RE: SSD 6303 - Barangaroo Stage 1A Public Domain

I refer to Planning & Infrastructure's recent exhibition of an Environmental Impact Statement (EIS) for the construction of the public domain around the Stage 1A area of Barangaroo South.

This submission comprises the City of Sydney's (the City's) comments on the proposed design, public domain issues and transport issues associated with the Stage 1A Public Domain package.

DRAWING NO.
LA_MP_AO_DA302

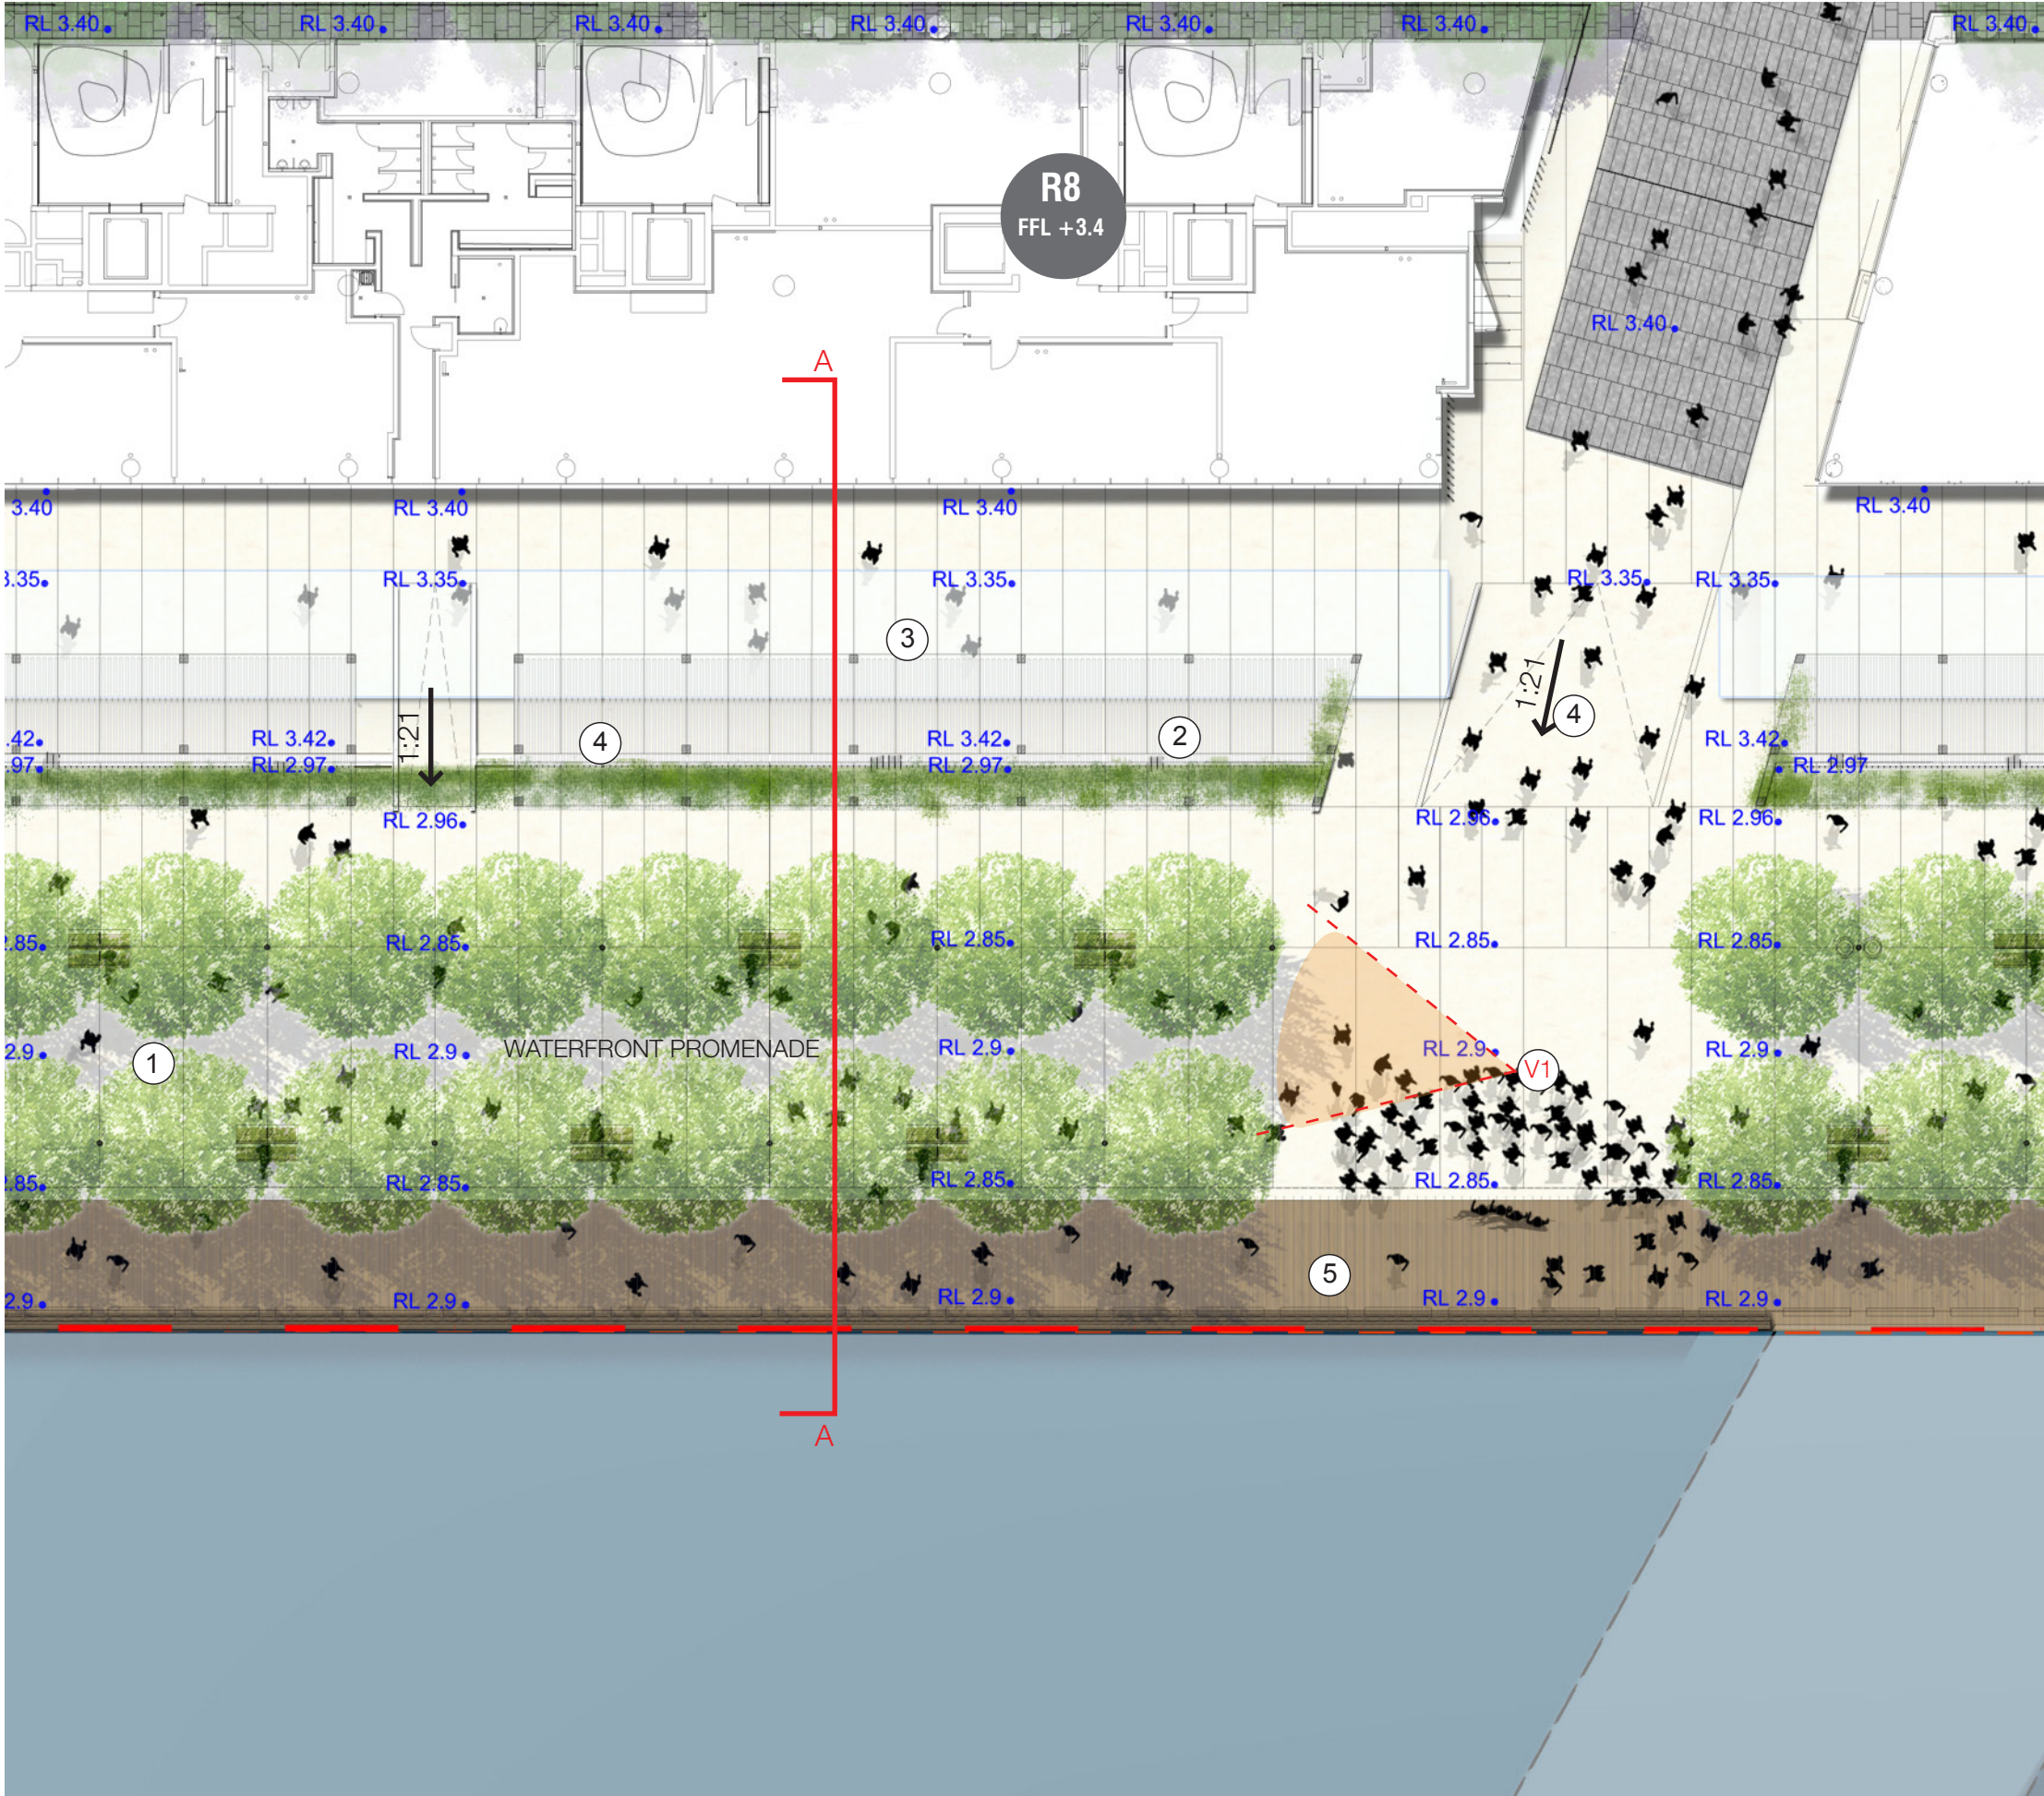
Further thought should be given to the change in level shown in "Waterfront Perspective View 2" (LA_MP_AO_DA304) and in "Section A-A Waterfront" (LA_MP_AO_DA302). A drop of 450mm between the terrace area and lower concourse represents a potential safety hazard. Consideration should be given to some visual and/or tactile means (change of paving colour or texture) to signal this level change. A handrail or some other barrier may be required to be installed if accidents occur, and this would be a less than desirable urban design outcome.

DRAWING NO.
LA_MP_AO_DA322

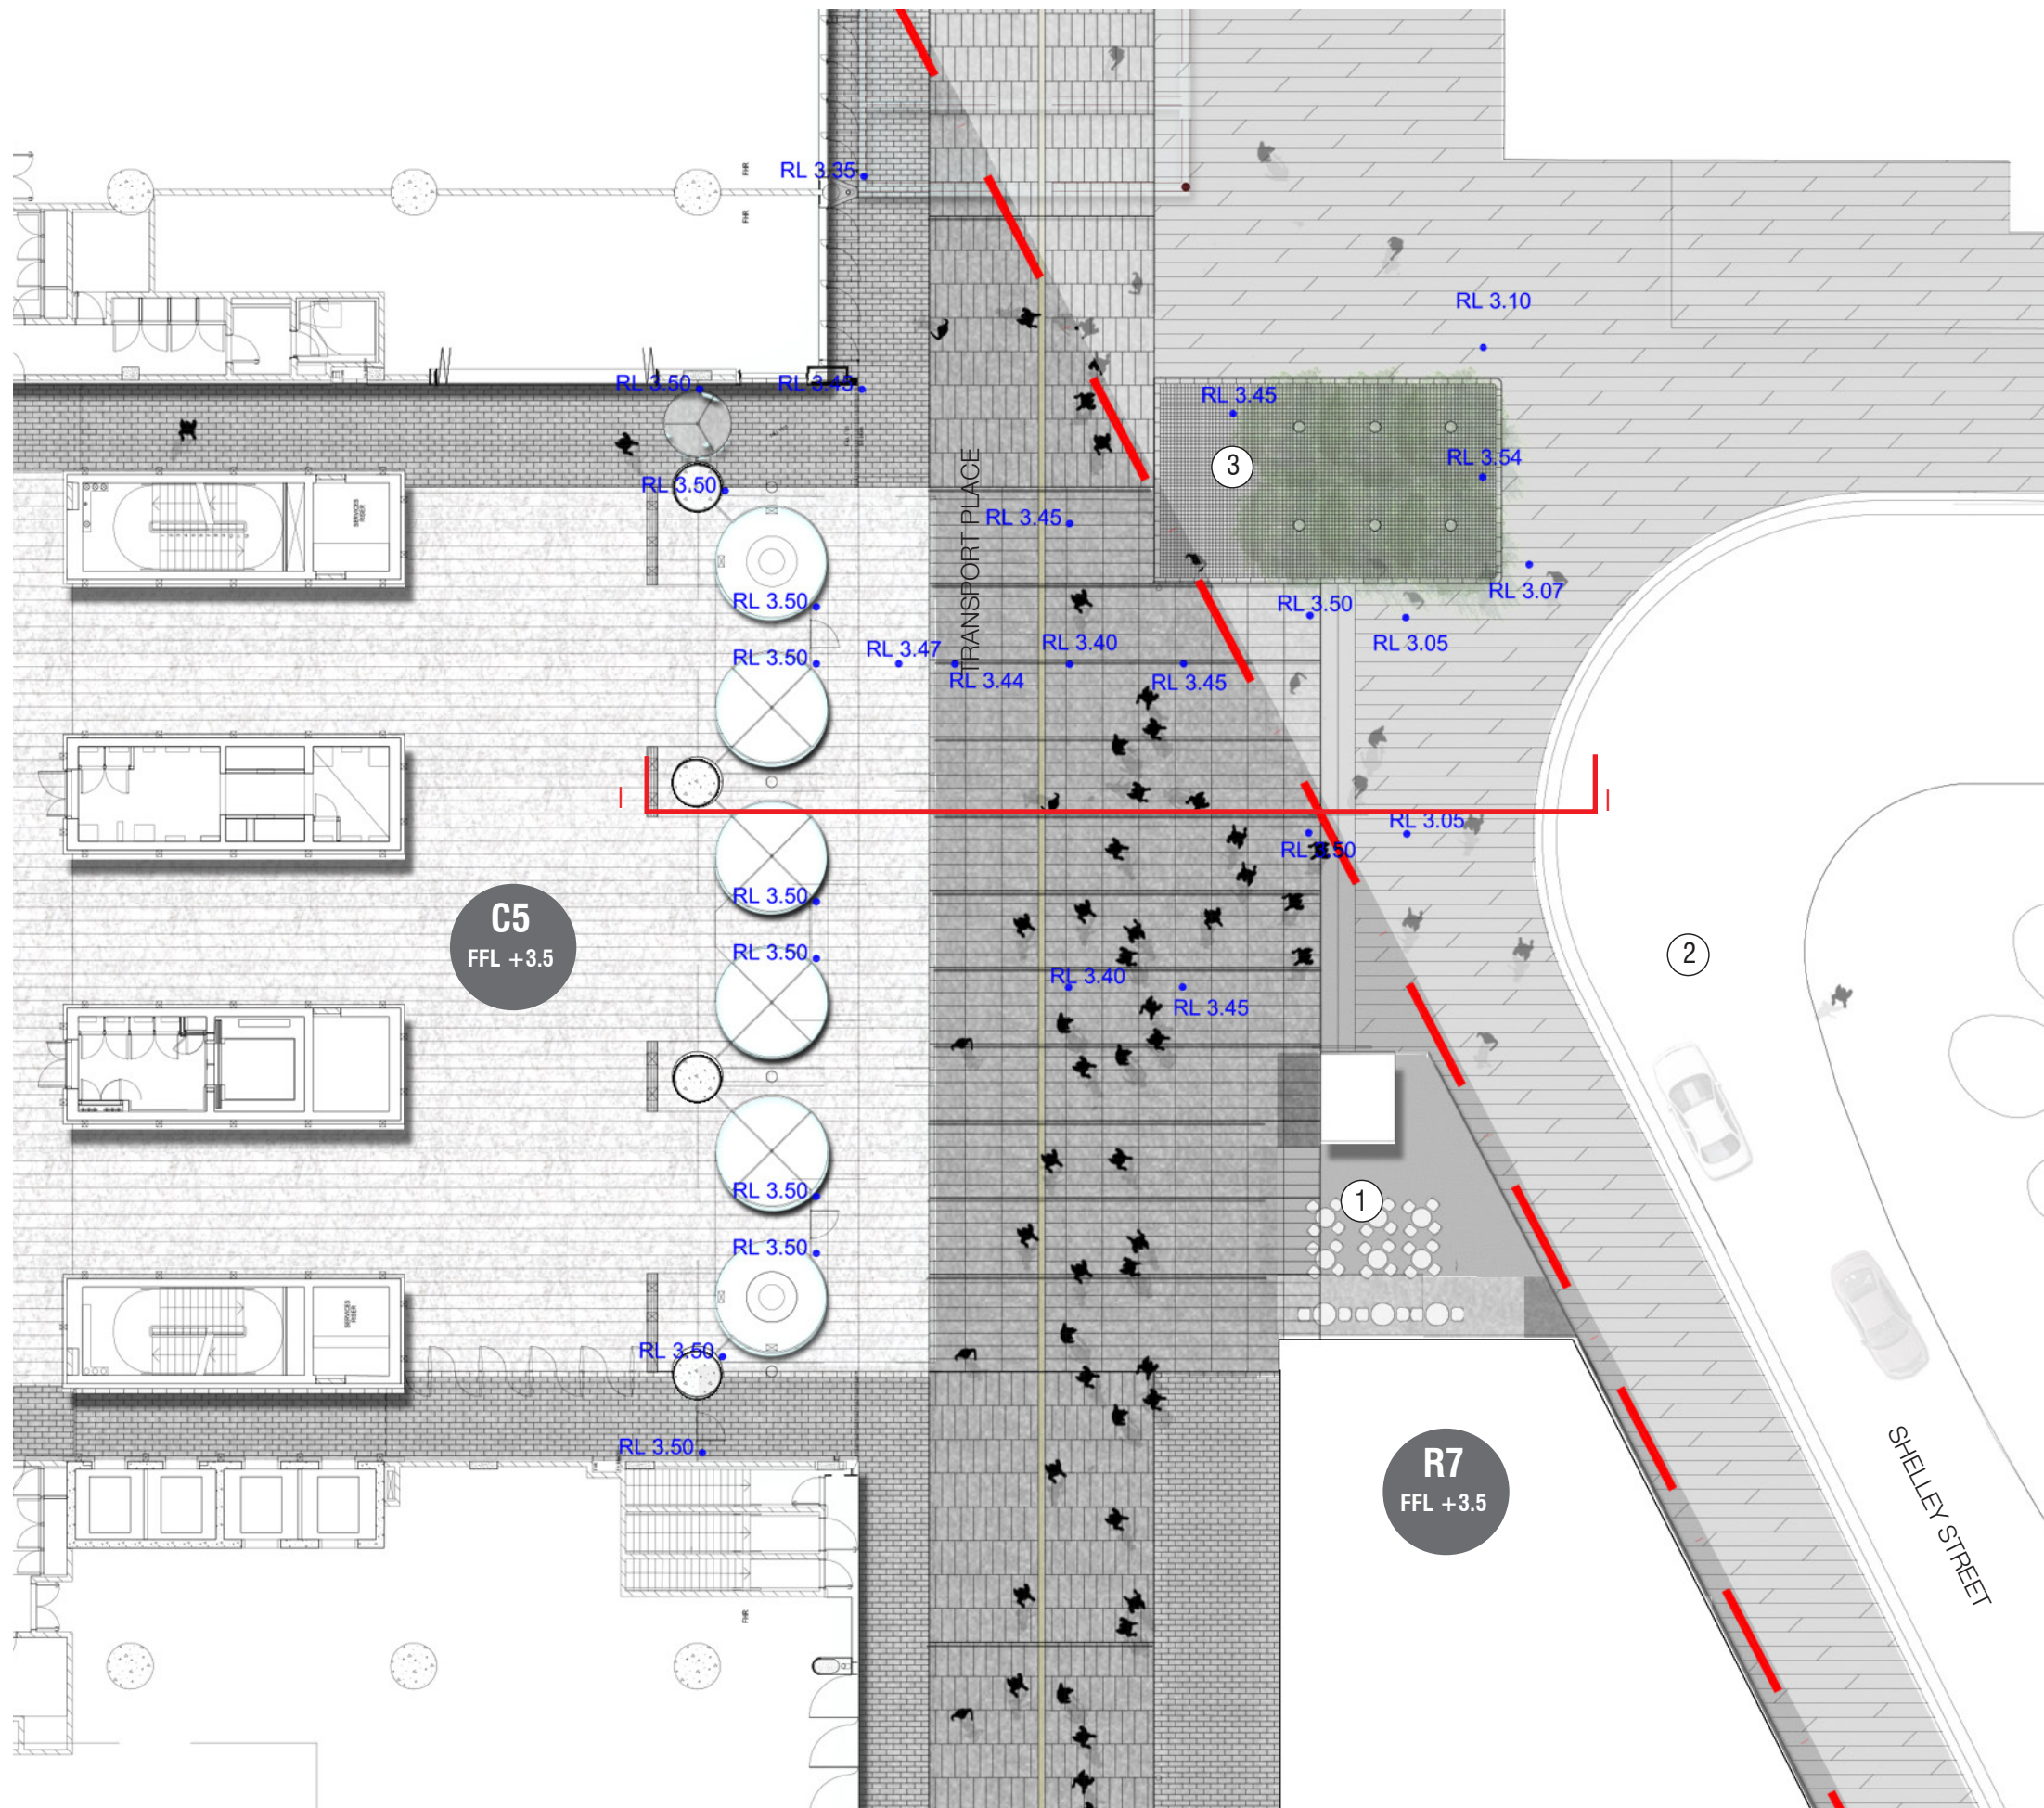
Hickson and Transport Places are denoted as new squares. Transport Place is not a new area but seems to have been made slightly larger. Its function as a public square is likely to be compromised given its junction with vehicular traffic. Hickson Place forms a new arrival space and is a key decision point for visitors before they head off from the bottom of the pedestrian bridge. The increase in space is a good addition at this important link.
